Approval of details reserved by condition imposed under BN/4/21/HH relating to condition 3-surface water drainage.

Magnolia Cottage Fontwell Avenue Eastergate PO20 3RZ

Arun District Council have decided to **REFUSE details reserved by condition for the following reasons:**

Trench soakaway using Polystorm Lite Geomodular units  
Landscaped areas only  
0.4m deep

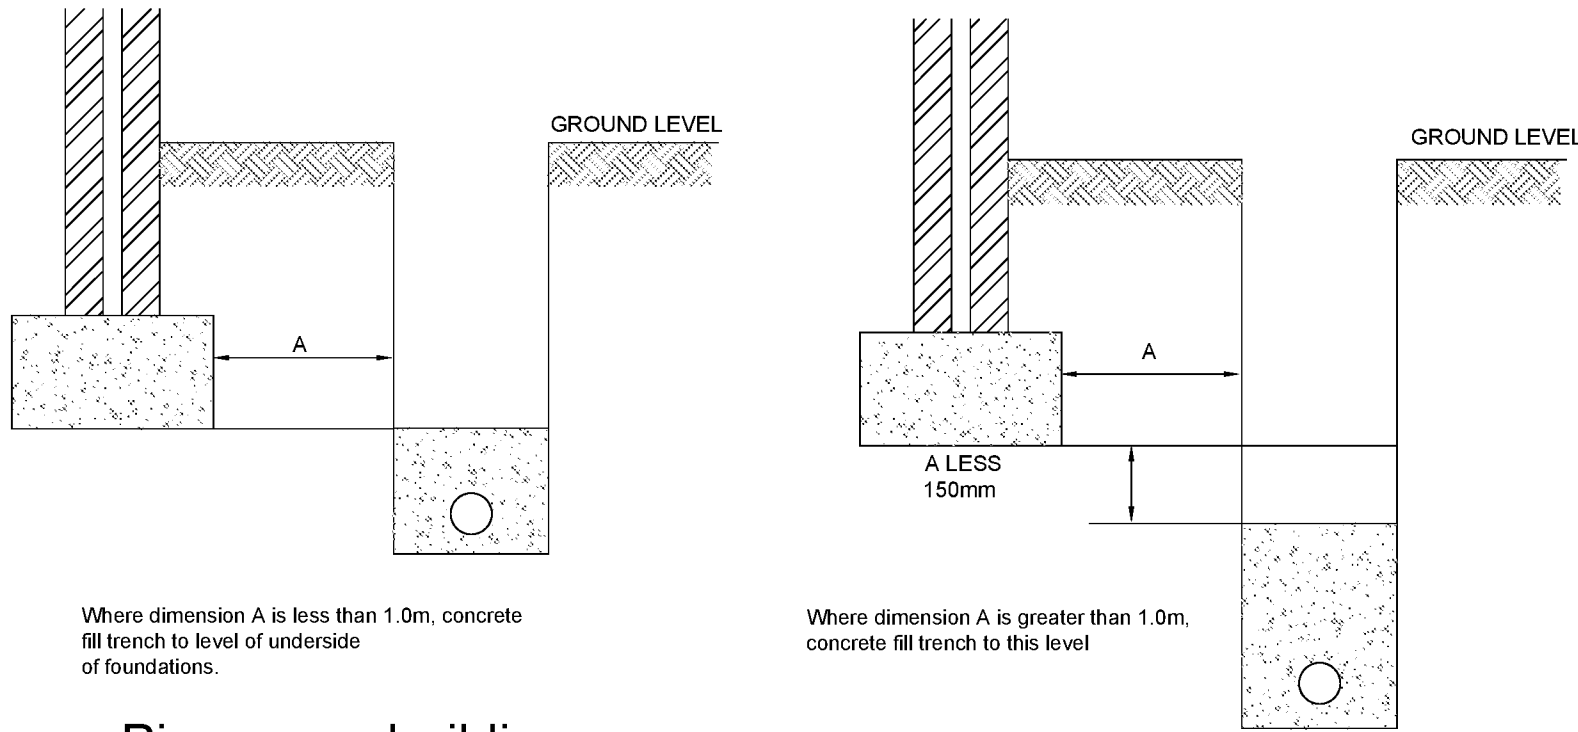
- The access point for carrying out maintenance and inspection of the soakaway should be stated, (and details given if this is an additional element of the design e.g. additional manhole).

4. The incoming pipe invert level is potentially below the 1:10 year water level within the soakaway. The applicant should confirm that the pipe is not likely to be surcharged during the 1:10 year storm. Or the pipe could be raised to provide a larger difference between the soakaways invert level and the pipe inlet invert level, or additional crates included within the design, to lower the 1:10 year water level.

5. The applicant should confirm that the soakaway is outside of the root protection zone (RPZ) for the trees located on the land where the soakaway is proposed.

450mmØ POLYPIPE BASIC  
SILT TRAP DETAIL

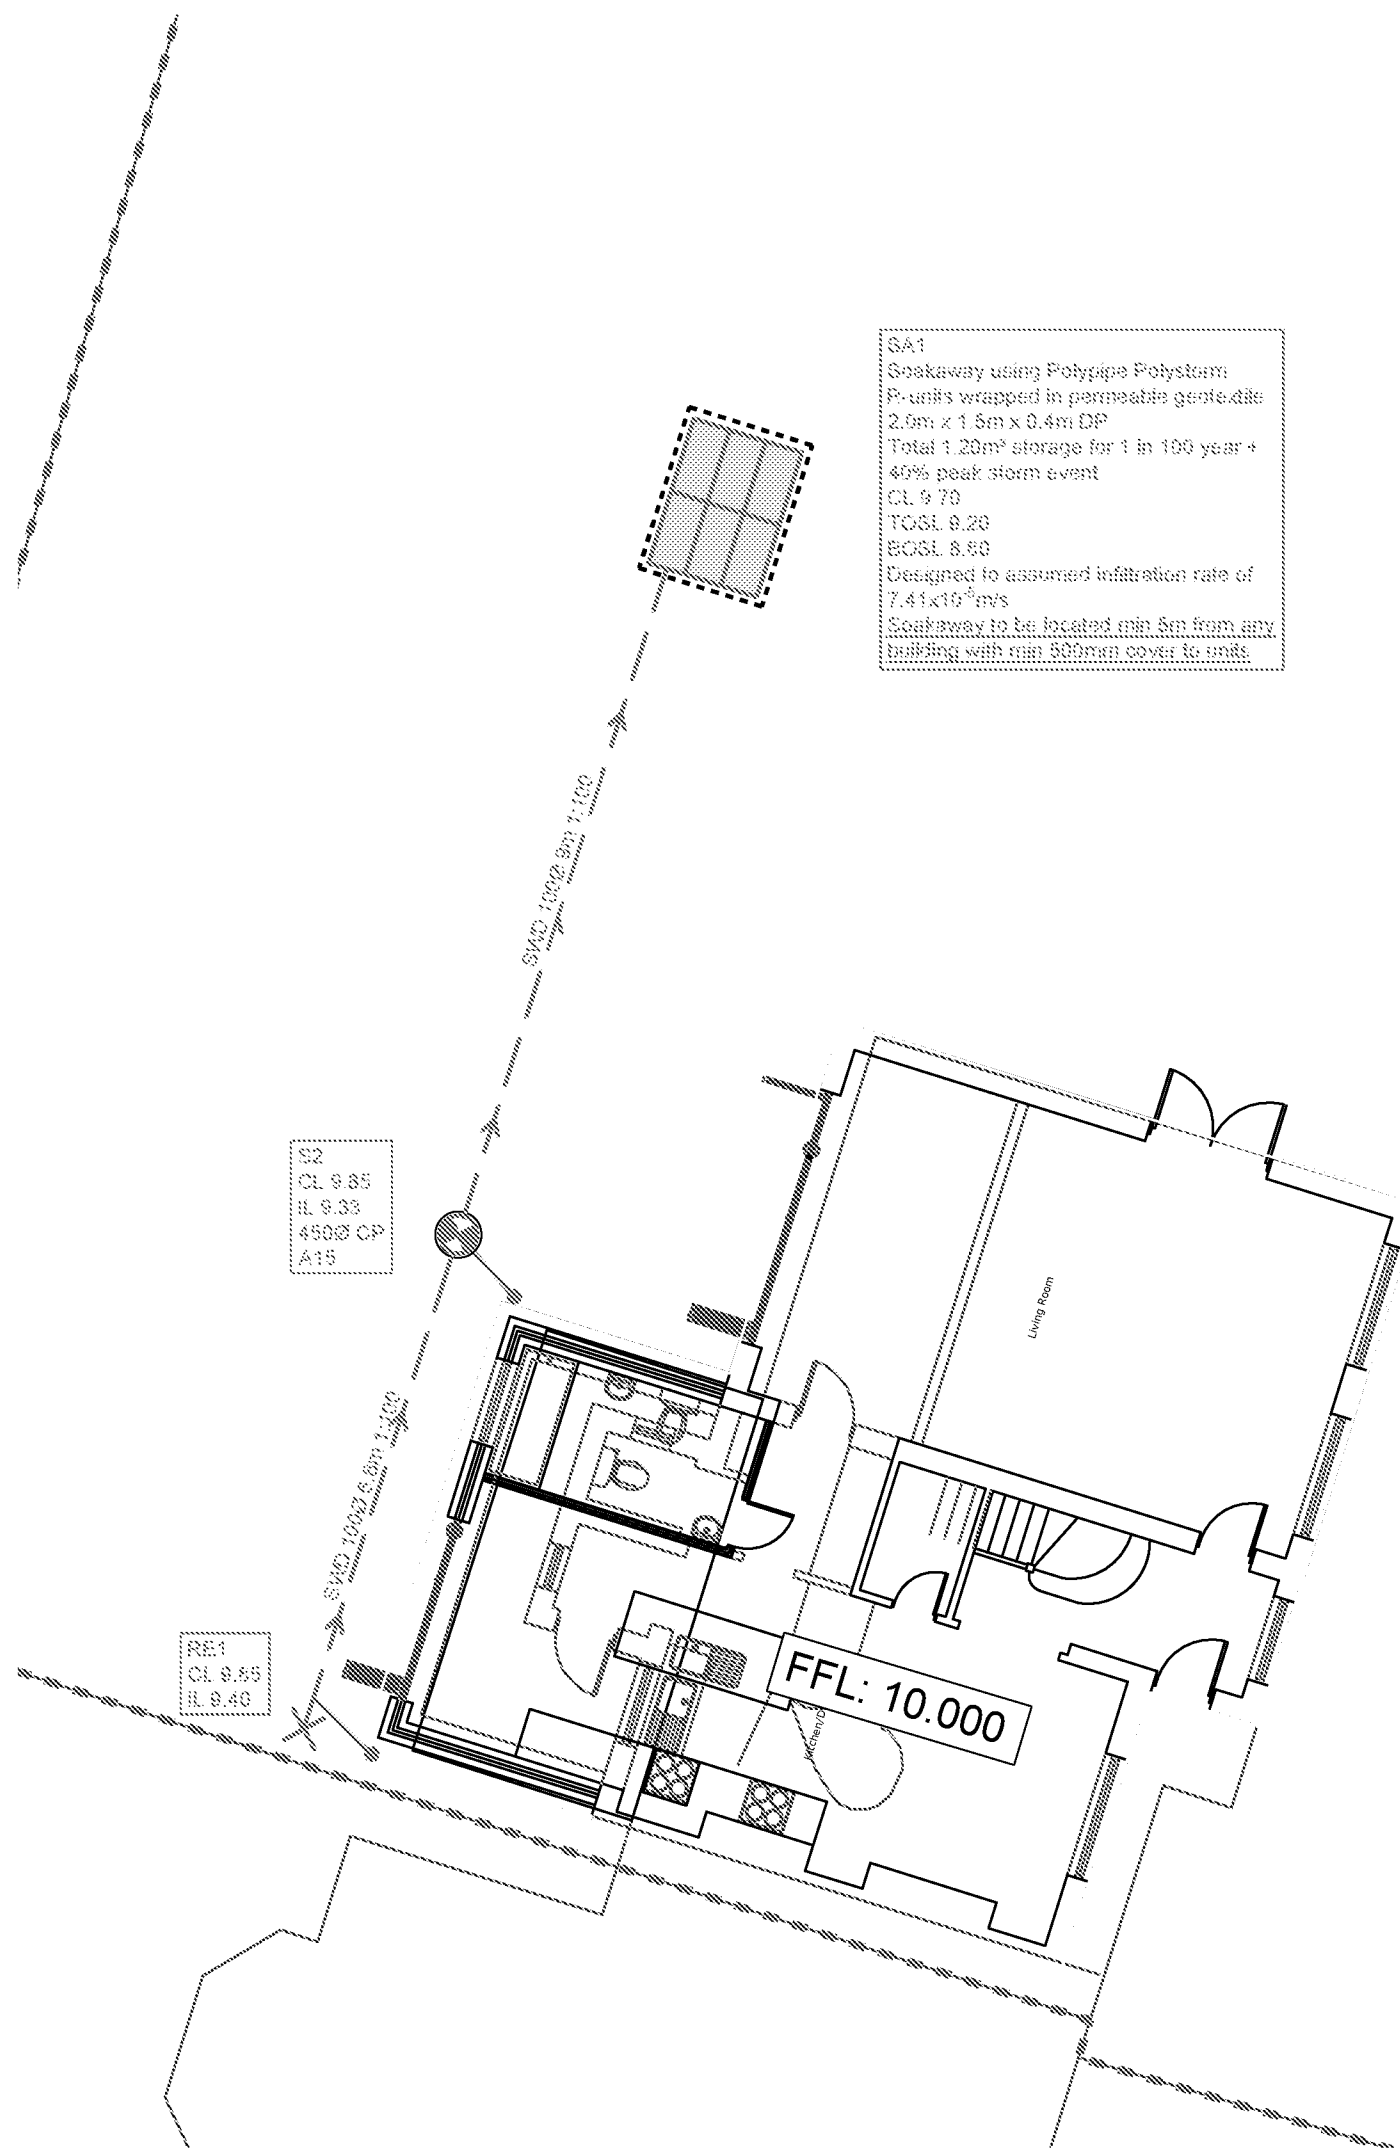
- The loading class for the cover on the sediment trap manhole (and any other manholes) should be stated.
